LANDSCAPE DEVELOPMENT PLANS

THE CITIZEN ON CONSTITUTION

PCD PROJECT NUMBER: PPR-22-29

DATE: 08.19.2022

L601

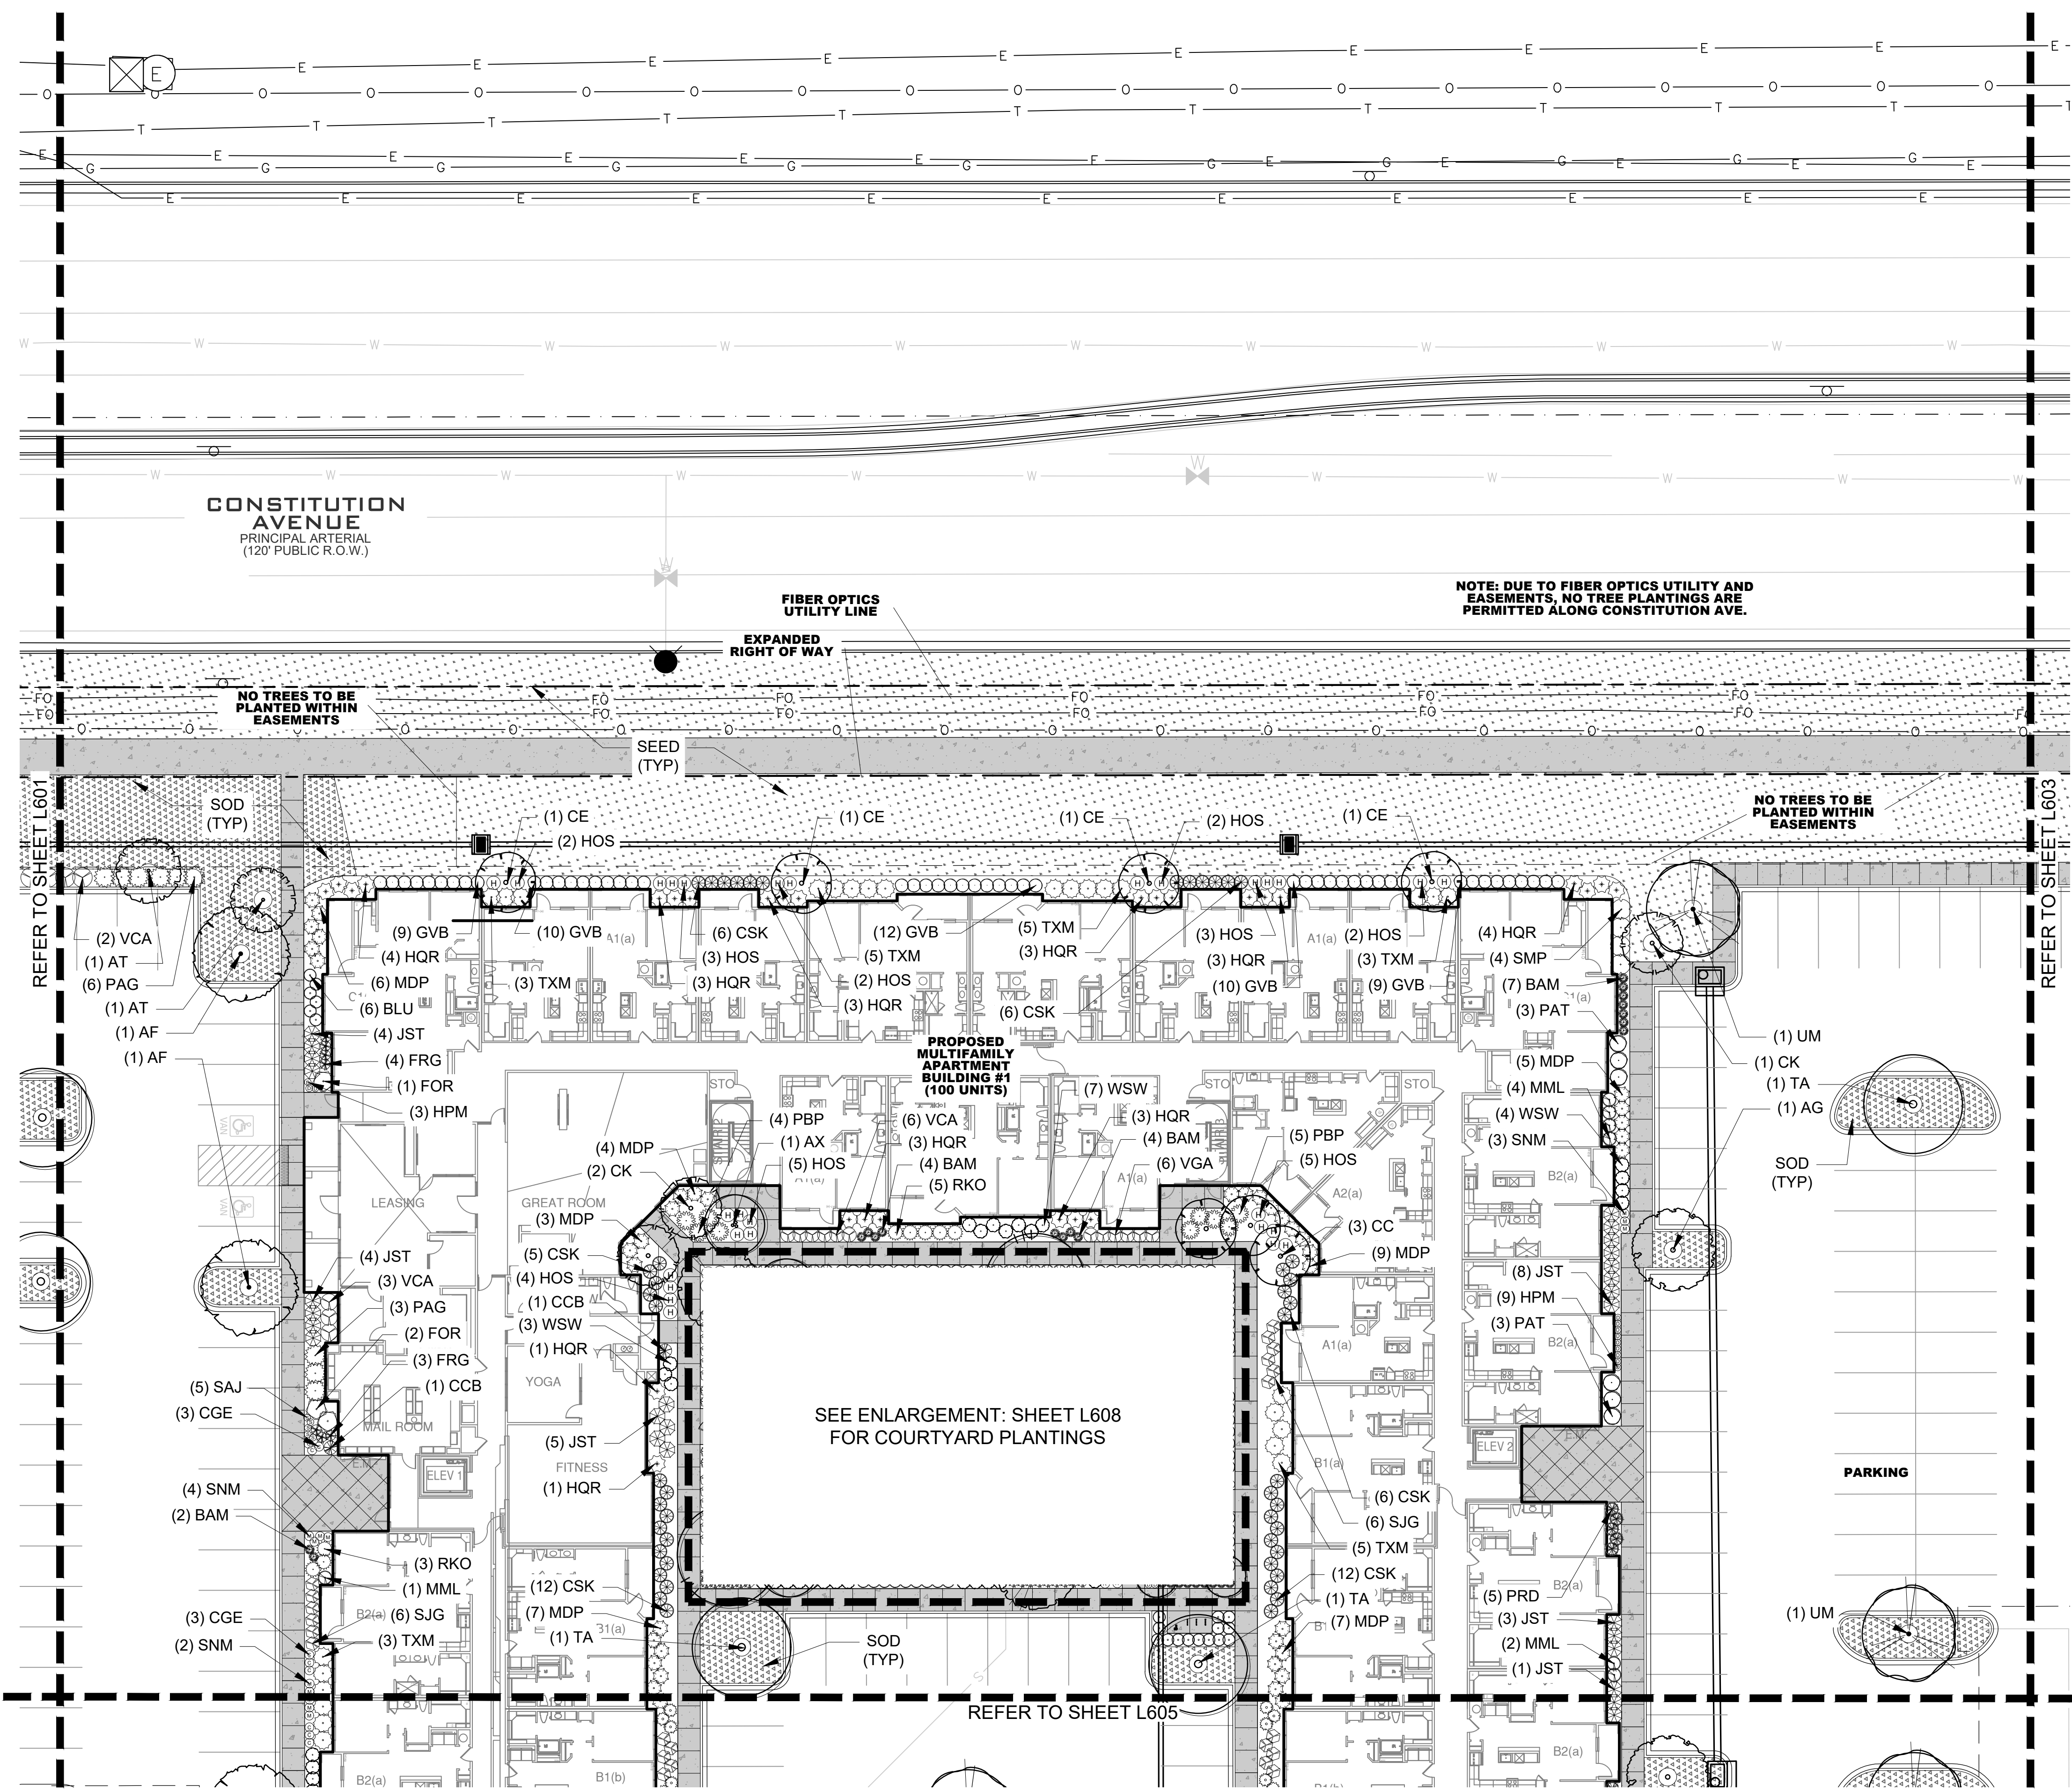
Coordinate with civil engineer regarding the material at the splitter islands and Central island at the roundabout.

The splitter islands shall have patterned stamped concrete per ECM detail SD_2-21 as indicated in the Construction Drawings.

Comments have been provided in the CD's regarding the requirements for the Central Island. Please coordinate and revise accordingly.
